Planning Application Ref: **AW/48/19/HH**

Location: **11 Chawkmare Coppice, Aldwick, PO21 3BU**

Description of works: **Rear two storey and single storey extension to existing residential dwelling (resubmission)**

BLOCK PLAN 1:500

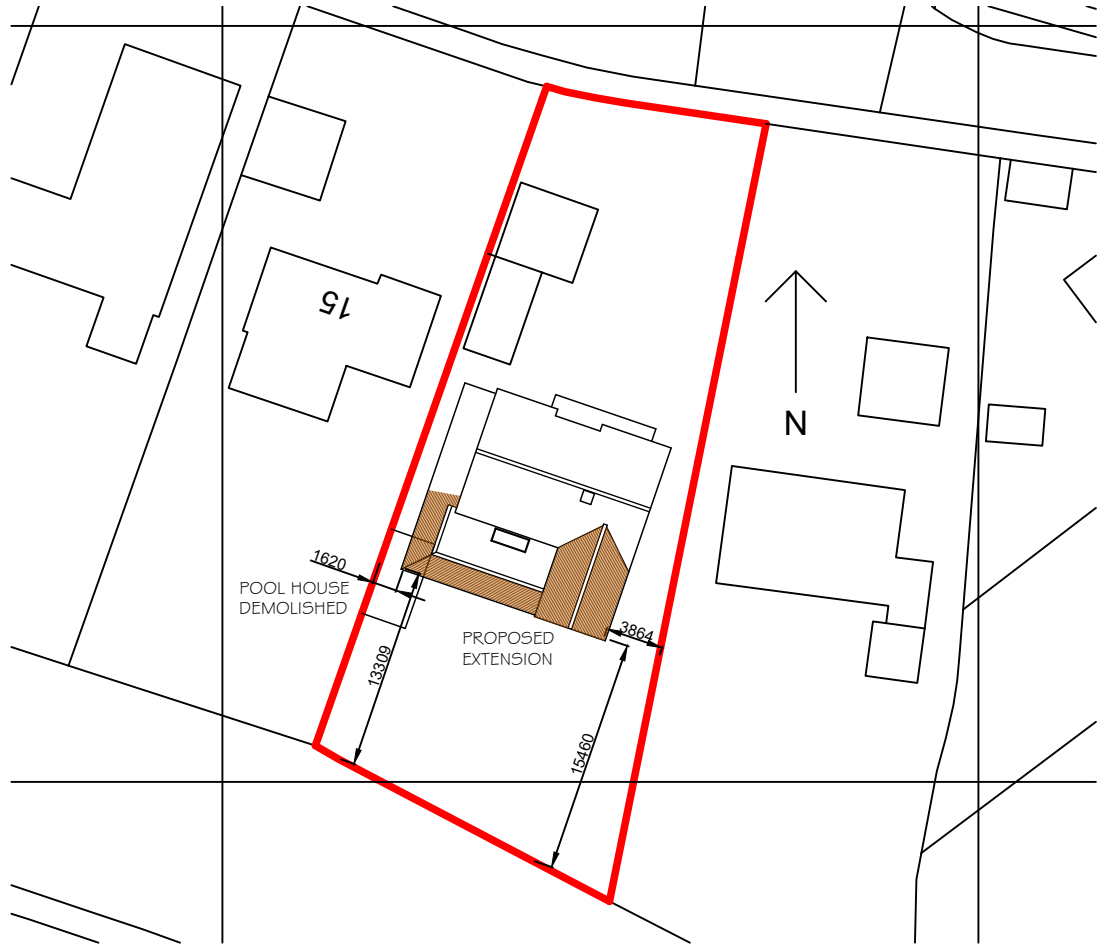
- The applicant is seeking to extend the south flank of the dwelling and which is to the rear of the plot.
- There are no significant trees within the site perimeter but there are trees growing on local authority land to the south which overlap the site both above and below ground. No arboricultural information has been submitted with the application - a requirement of BS5837:2012.

- Of special significance is a mature Monterey pine which is the subject of a Tree Preservation Order. The proportion of this tree's root protection area (RPA) which lies within the perimeter of the above plot is largely under hard surfacing (paving slabs) - which if left undisturbed affords a degree of protection.

- No Construction Management Plan has been provided so we cannot be sure that off-site trees will not be adversely affected by these proposals, although there seems to be ample space on the plot to avoid any interference with them.

- If the applicant can provide us with written confirmation that no demolition or construction work (e.g. disturbance of hard surfaces, alteration of ground levels, soil contamination, storage of plant or materials) will occur within 6metres of the rear boundary-line then I would be prepared to waive the requirement for the applicant to employ an arboricultural consultant to survey the site and prepare a tree protection plan - and thus lend the scheme my support.

- Subject to confirmation of a restricted working zone as described above, I would raise **no objection** to this application on arboricultural grounds; with the following or similarly worded condition to be applied to any permission:
 - There will be no disturbance of existing hard surfaces, alteration of ground levels, soil contamination, storage of plant or materials to within 6metres of the southern boundary of the site.
